03DRB-00181 Major-Vacation of Public Easements  
03DRB-00182 Minor-Prelim&Final Plat Approval

SURVEYS SOUTHWEST, LTD. agent(s) for MARK ADDY request(s) the above action(s) for all or a portion of Tract(s) A-1, **4 HILLS VILLAGE SHOPPING CENTER & APARTMENT COMPLEX**, zoned SU-1 special use zone, PDA, RES. & COMM., located on CENTRAL AVE SE, between DORADO PL SE and TRAMWAY BLVD SE containing approximately 1 acre(s). [REF: ZA-80-52, ZA-82-70, 02DRB-01464, 02DRB-01907] (L-22)

**PLAT OF
TRACTS A-1 & A-2, FOUR HILLS VILLAGE
SHOPPING CENTER AND APARTMENT COMPLEX
SECTION 27, T. 10 N., R. 4 E., N.M.P.M.
CITY OF ALBUQUERQUE
BERNALILLO COUNTY, NEW MEXICO
DECEMBER 2002
SHEET 1 OF 2**

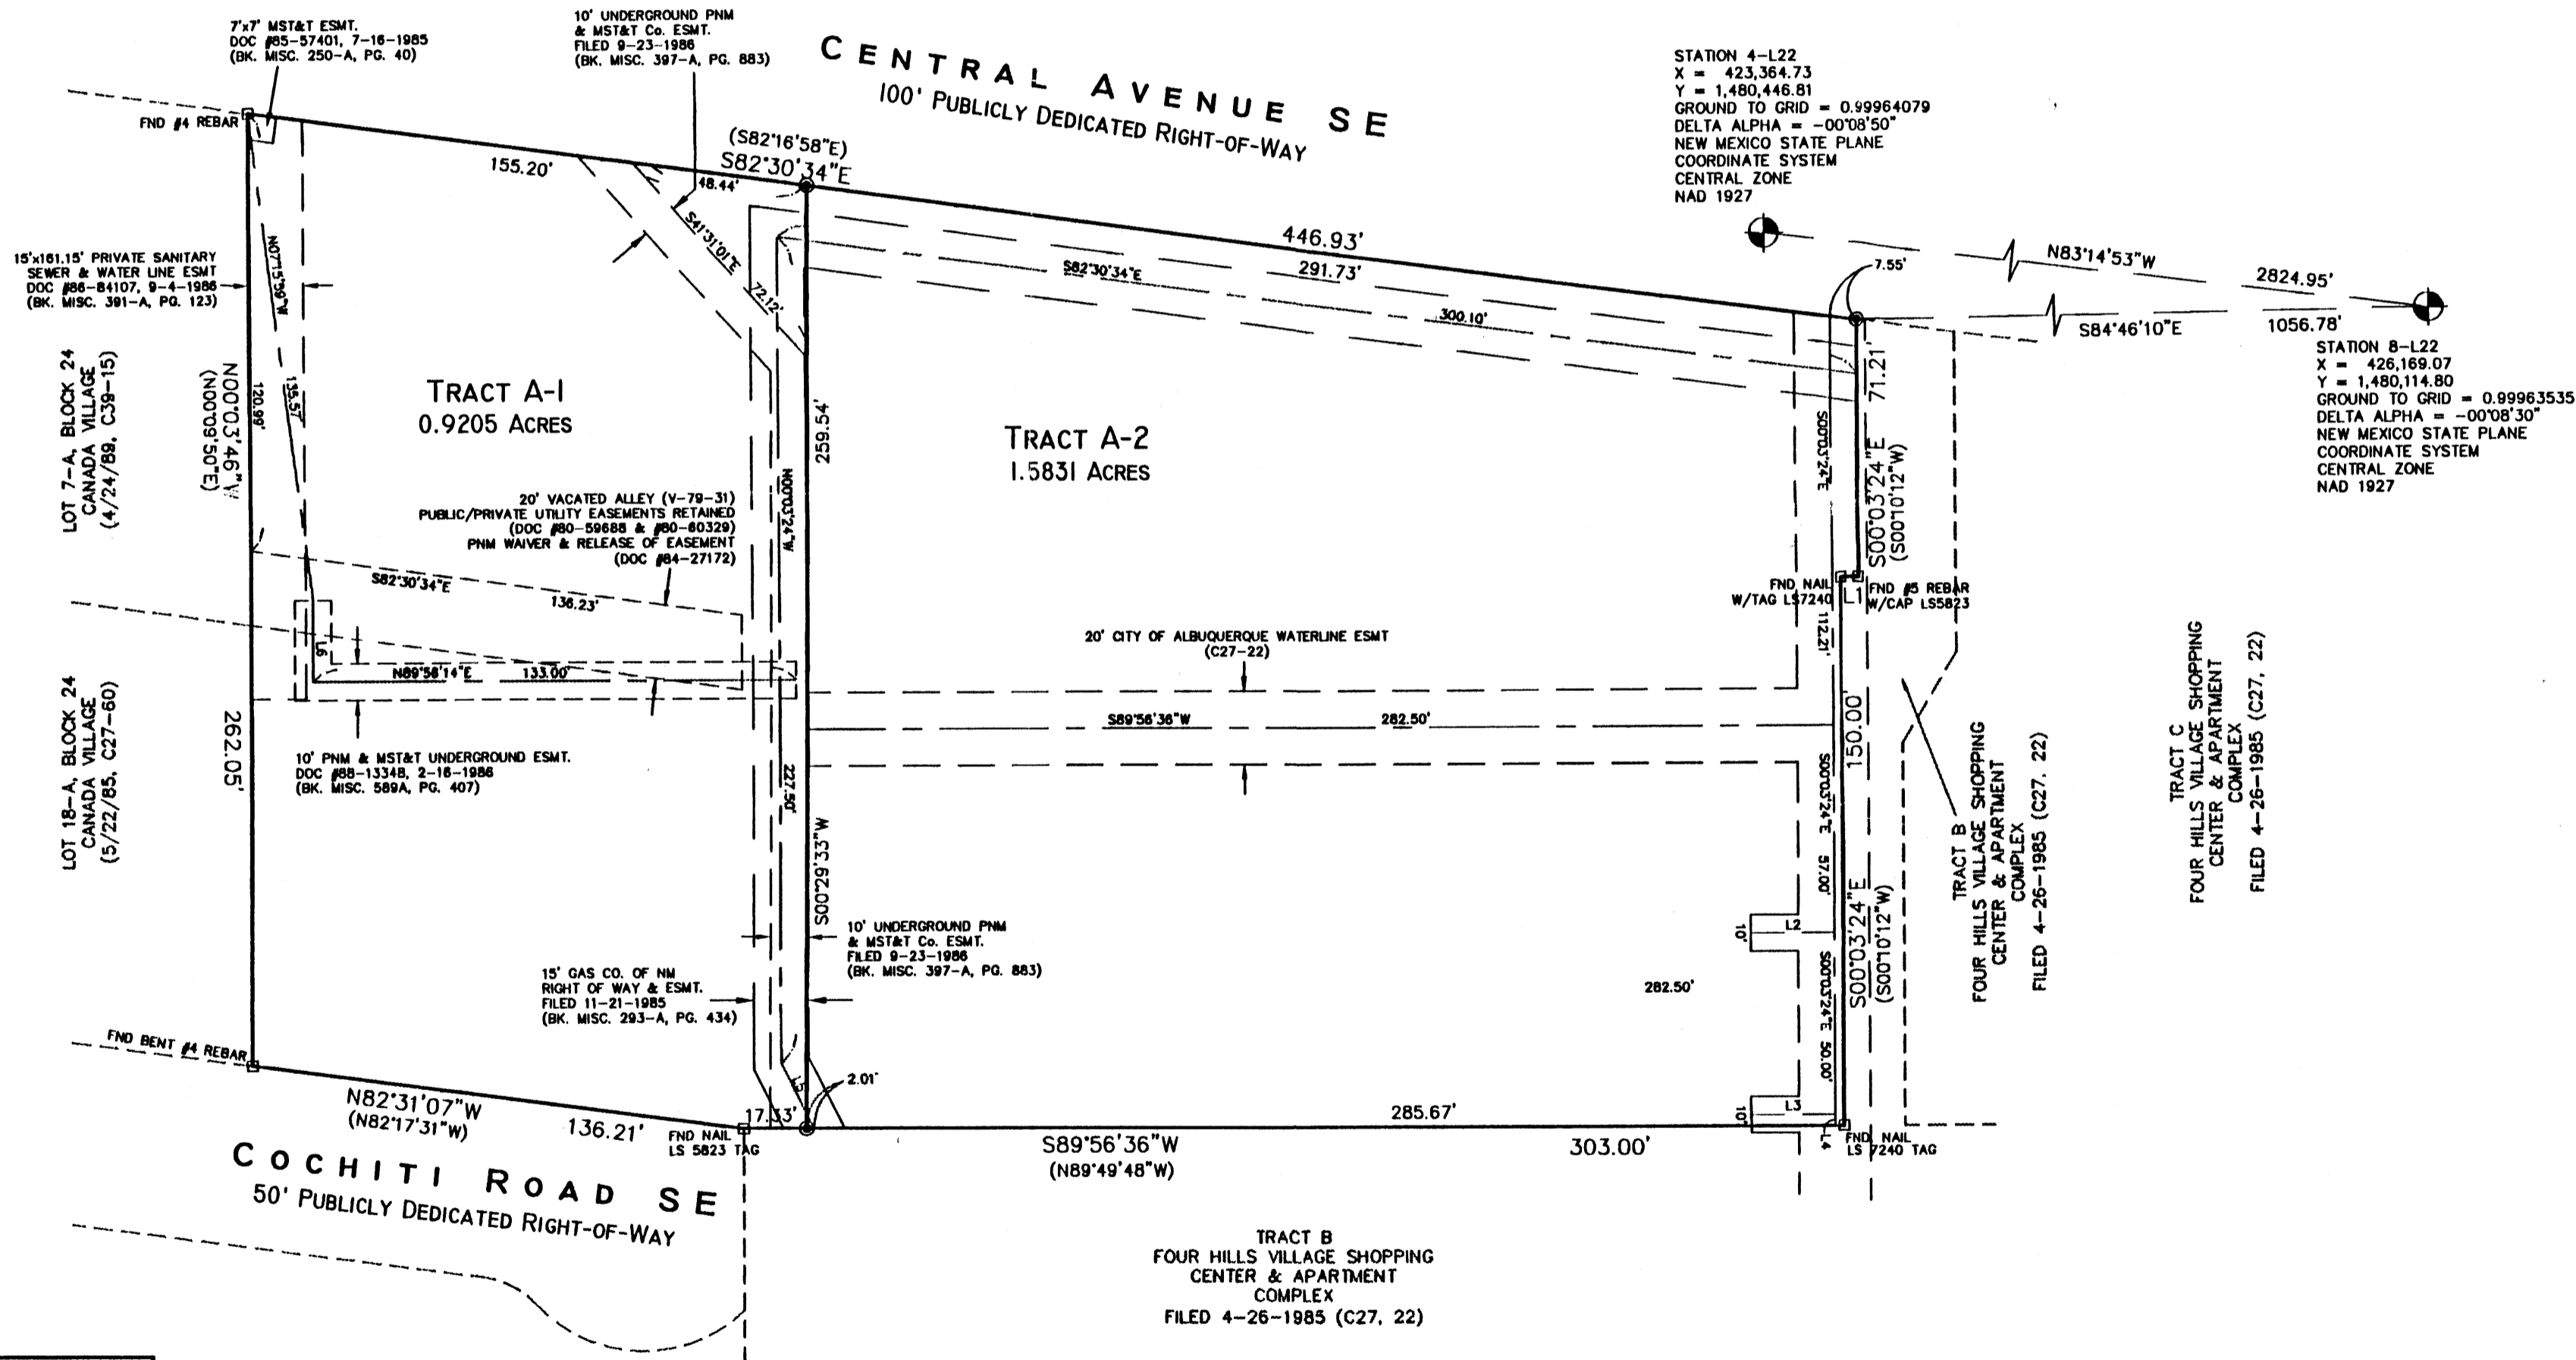
A copy of V-79-31 is needed. Refer to the agencies having interest in the easement(s) for comments on the vacation request. Dedication of right-of-way is needed on Central, 10 ft from the face of the curb.

Be sure to put the Project # & Application # on the plat as well as the purpose of the platting action.
